## Lake House – Corrections Response Letter

Response to: 2012-200 Lorenzini Remodel 3R  
Dated: July 19, 2021  
Permit #: 2012-200  
Project address: 3310 97th Ave SE  
Mercer Island, WA 98040

**Re:** *Lorenzini Remodel (Lake House) at 3310 97th Ave SE Permit No. 2012-200*

MAIN LEVEL FLOOR PLAN
A2.03

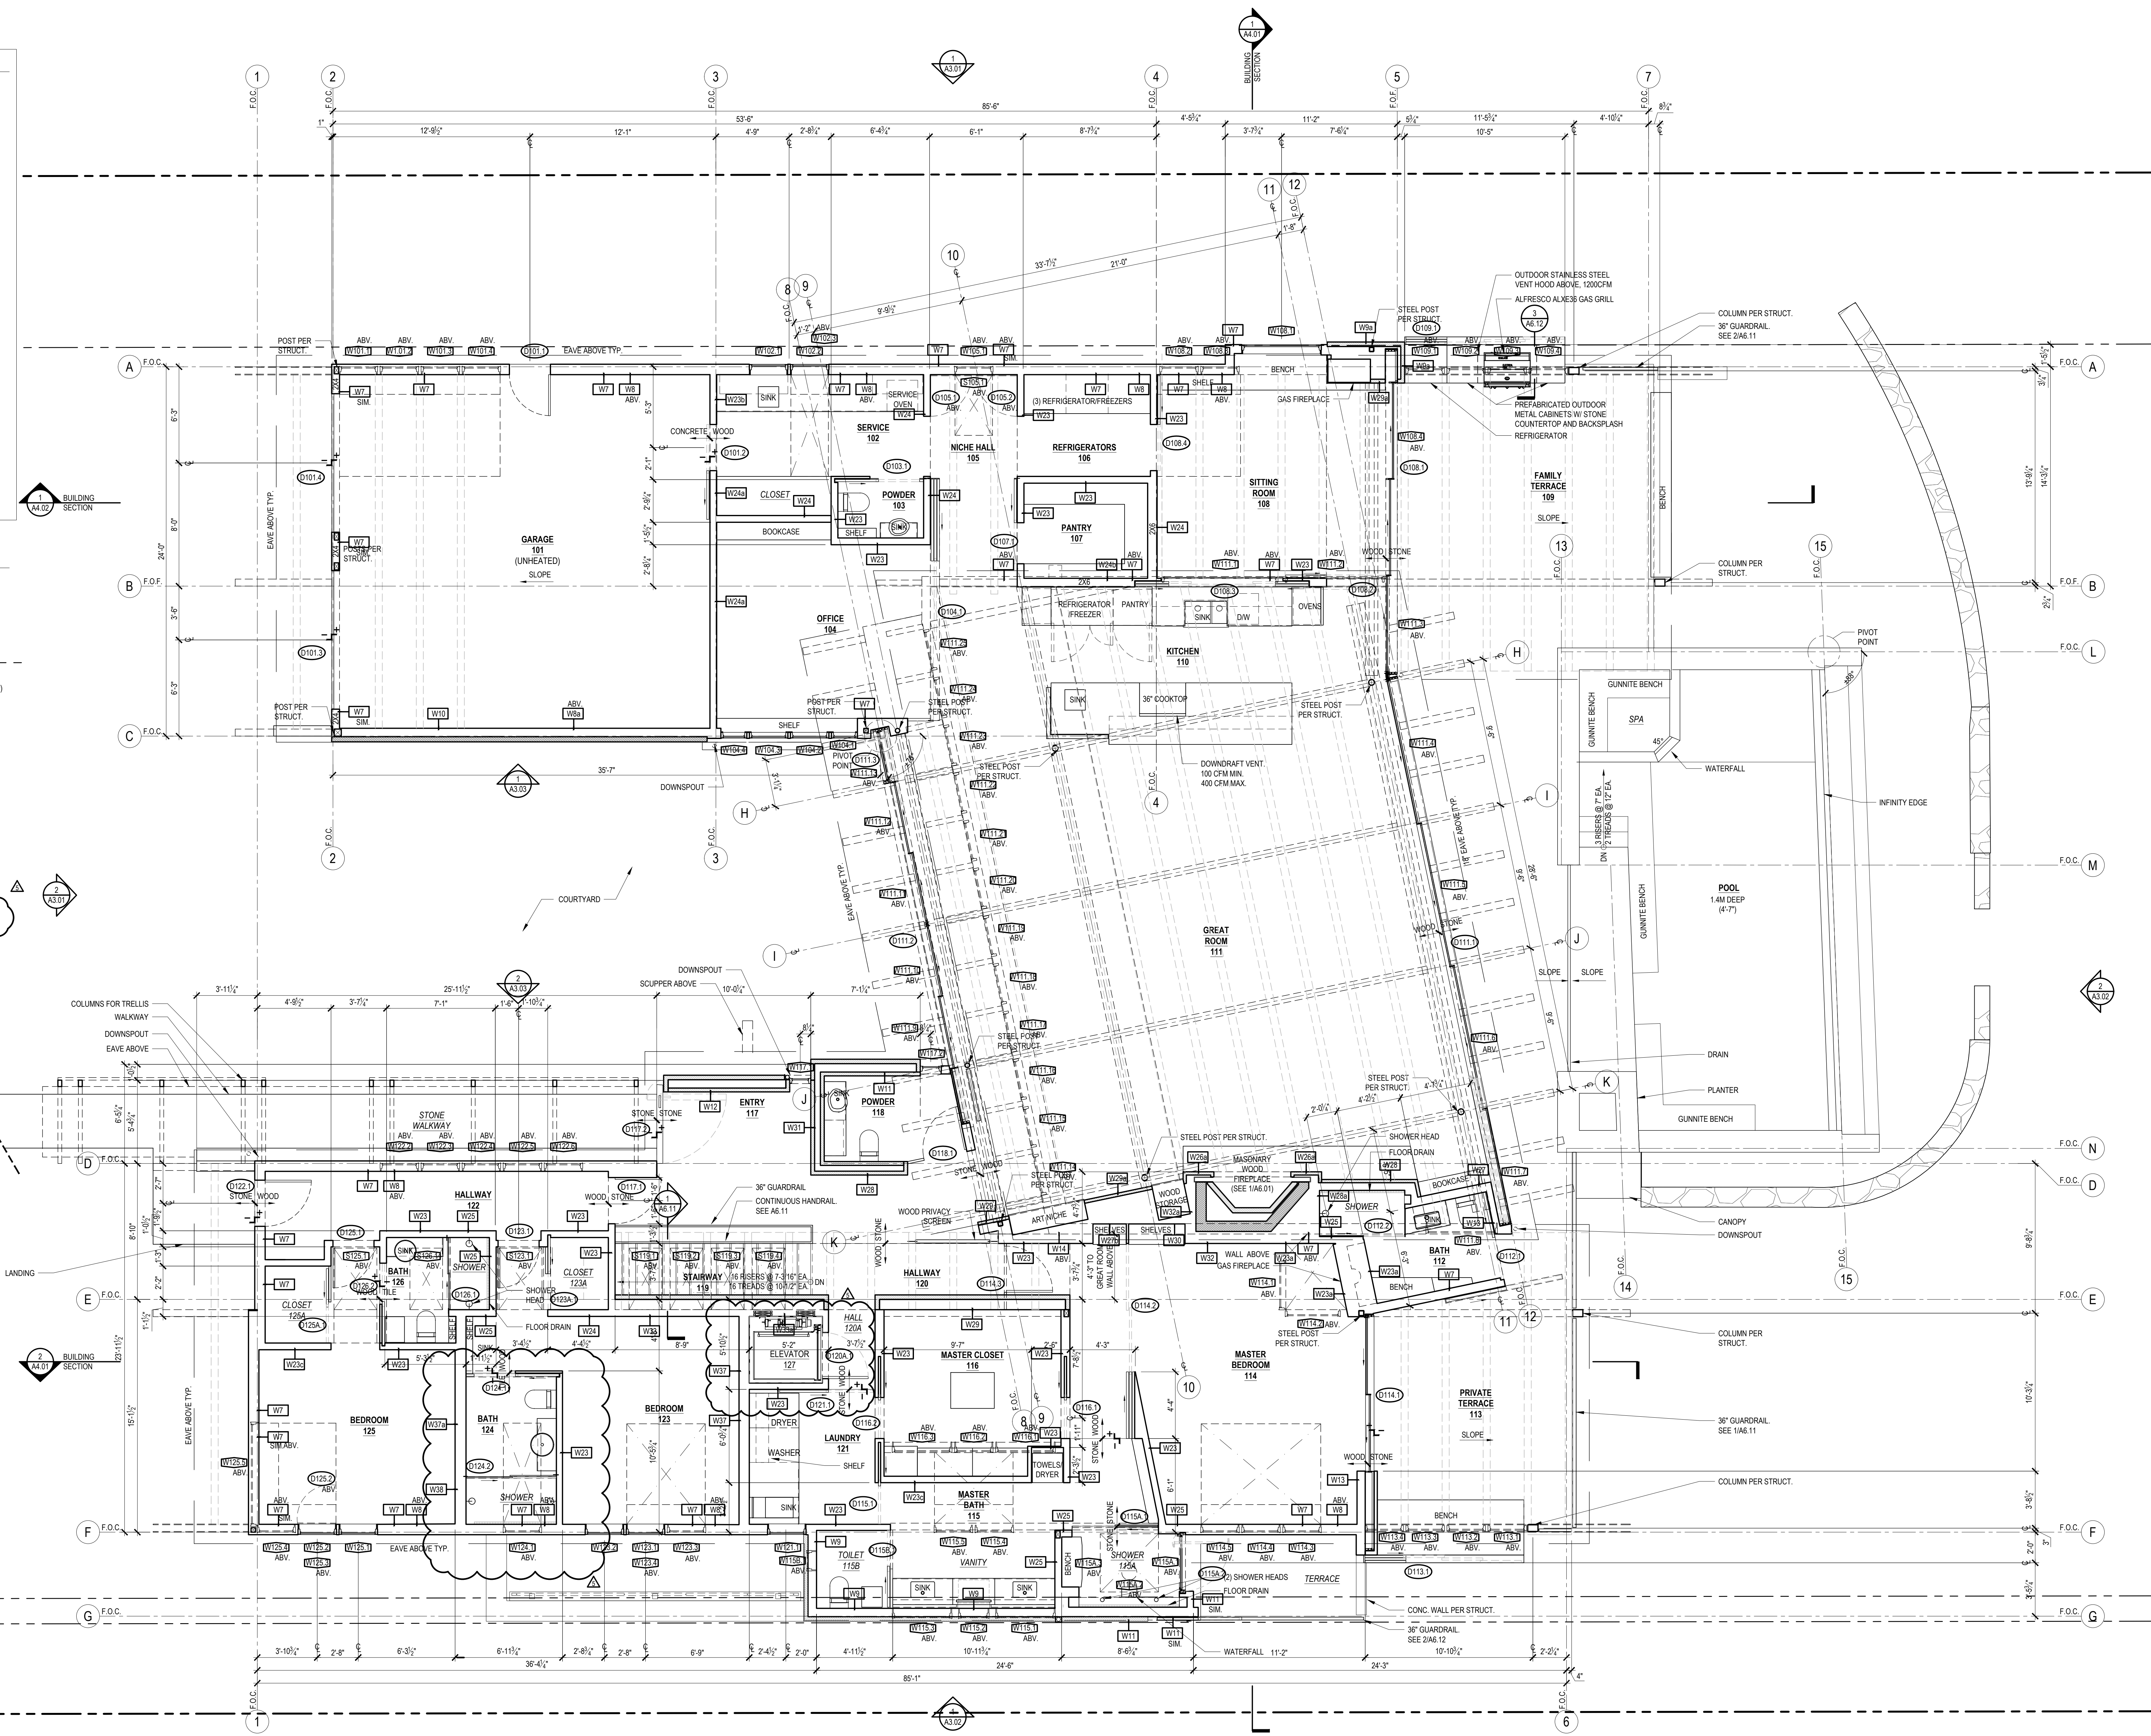
1. Mechanical ventilation will not technically be a separate permit. Please correct the note on Sheet A2.02.

**See updated note in sheet A2.02.**

1 GARAGE SECTION
1/2" = 1'-0"

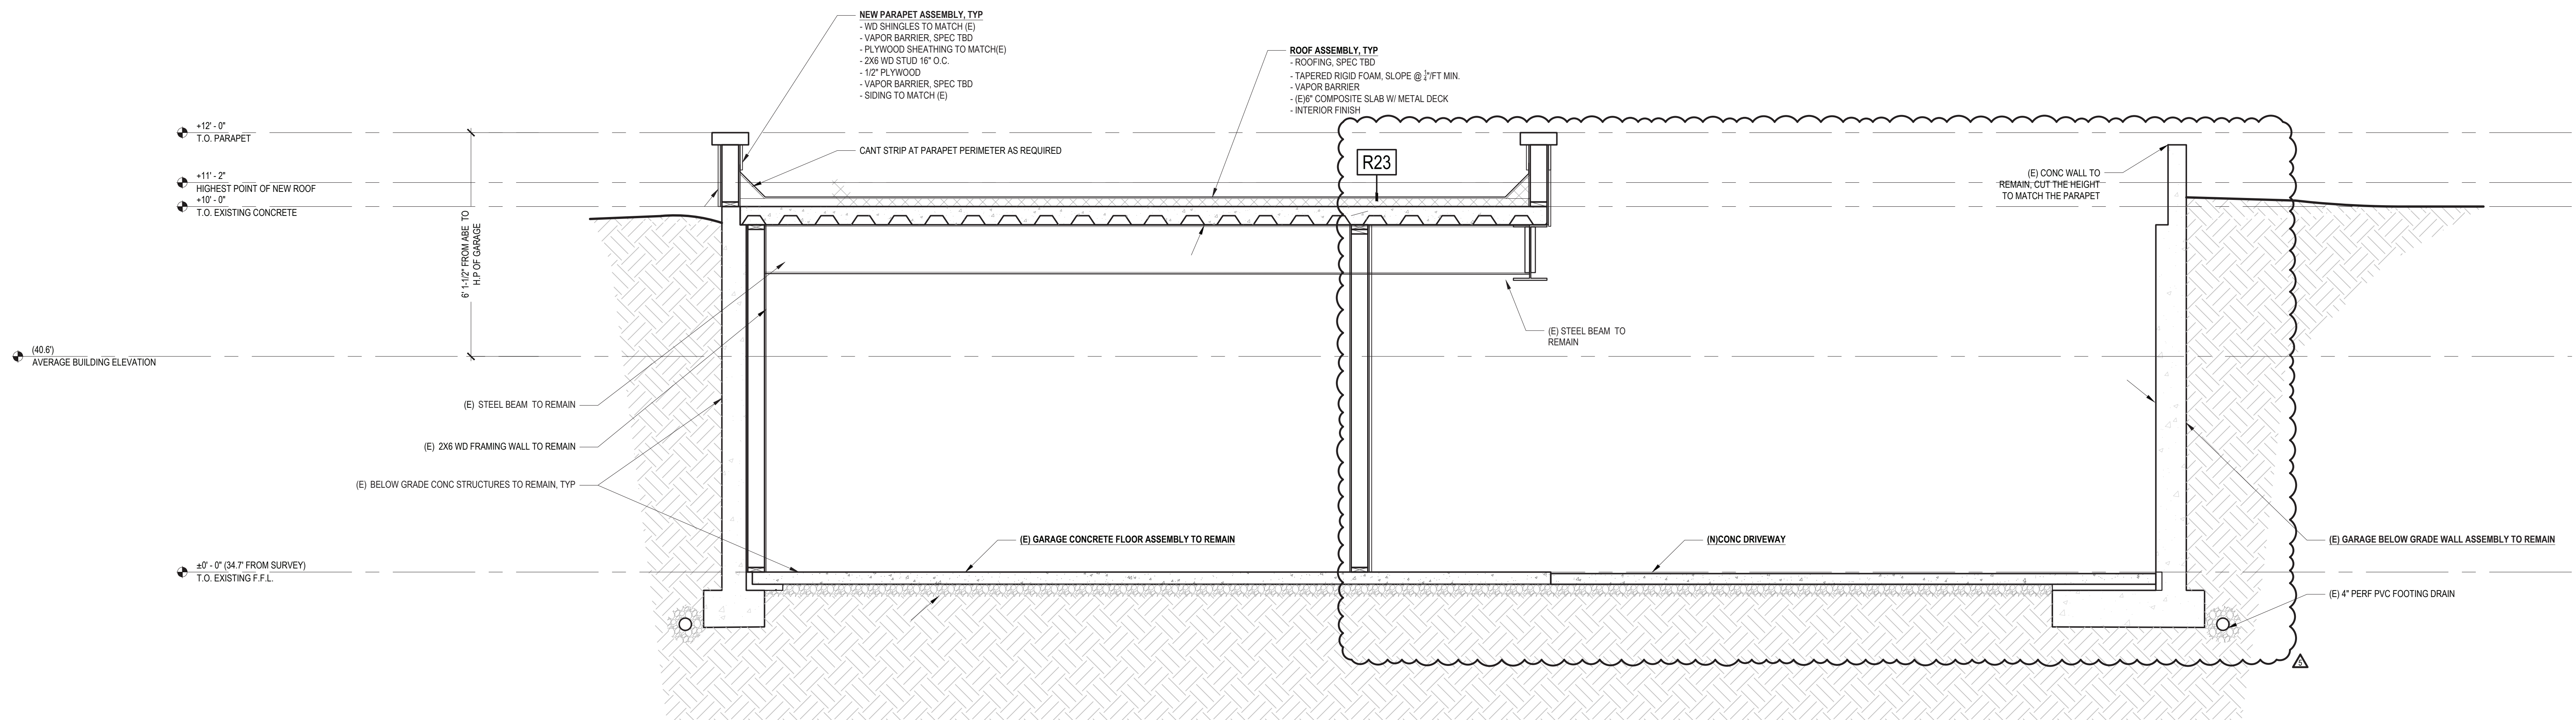
2. Details 16/S4.1 and 17 & 18/S4.2 show insulation above the roof sheathing. This does not appear to coordinate with the Roof Type R7 above the garage. Please clarify intent or revise the structural details to coordinate with your design.

1. Section 1/A4.02 shows the roof sheathing dropped along Grid 2.5 at the roof over the garage. Detail 17/S4.2 is cut at this location on the Roof Framing Plan, and it specifically does not show a drop in the roof level. Resolve discrepancy.

**- See A4.02 for updated garage roof section.**

**- The structural details are revised to coordinate with the roof types, see updates in 16/S4.1 and 17&18/S4.2.**

*Detail 16/S4.1, 17/S4.2, and 18/S4.2 have been revised to show the updated roof assemblies and match the architectural plans.*
